**Re: McKinley Bicycle Center/ Phase 1 Renovation.**  
**3333 Truman St. NE**  
**Traffic Circulation Layout**  
Architect's Stamp 11-4-21 (G17-D091)

The TCL submittal received 02-10-2022 is approved for Building Permit with. A copy of the stamped and signed plan will be needed for each of the building permit plans. Please keep the original to be used for certification of the site for final C.O. for Transportation.

Reference: TCL Comments (G17-D091)  
McKinley Bicycle Center – Phase I Renovations

A1 TRANSPORTATION CIRCULATION LAYOUT
1" = 20'-0"

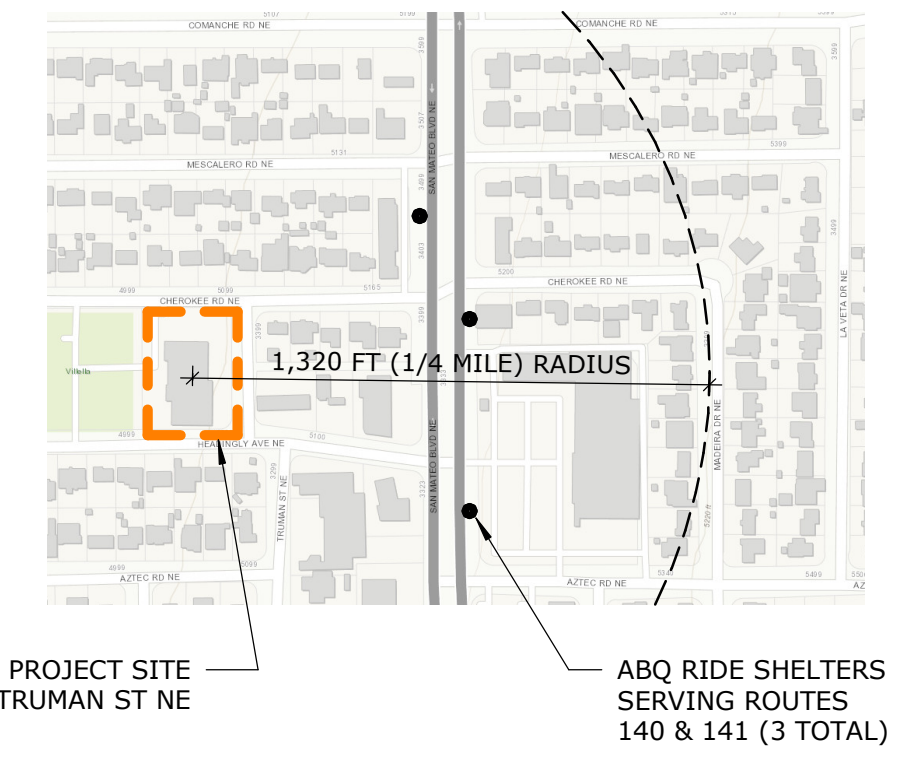
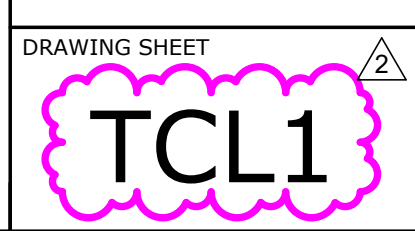
- 1) Sidewalk keyed note: *Keyed note 32 13 13.SW description has been revised to reference COA standard detail 2430 as requested.*
- 2) Apron keyed note: *Keyed note 32 13 13.SA description has been revised to reference COA standard detail 2425 as requested.*
- 3) Detectable warning devices at aprons: *Detectable devices at aprons have been deleted as requested.*
- 4) Detectable warning devices at corner curb ramps: Detectable devices at corner curb ramps have been deleted and will be installed per City and ADA standards as part of the deferred phase 2 improvements identified in the previously provided infrastructure list.
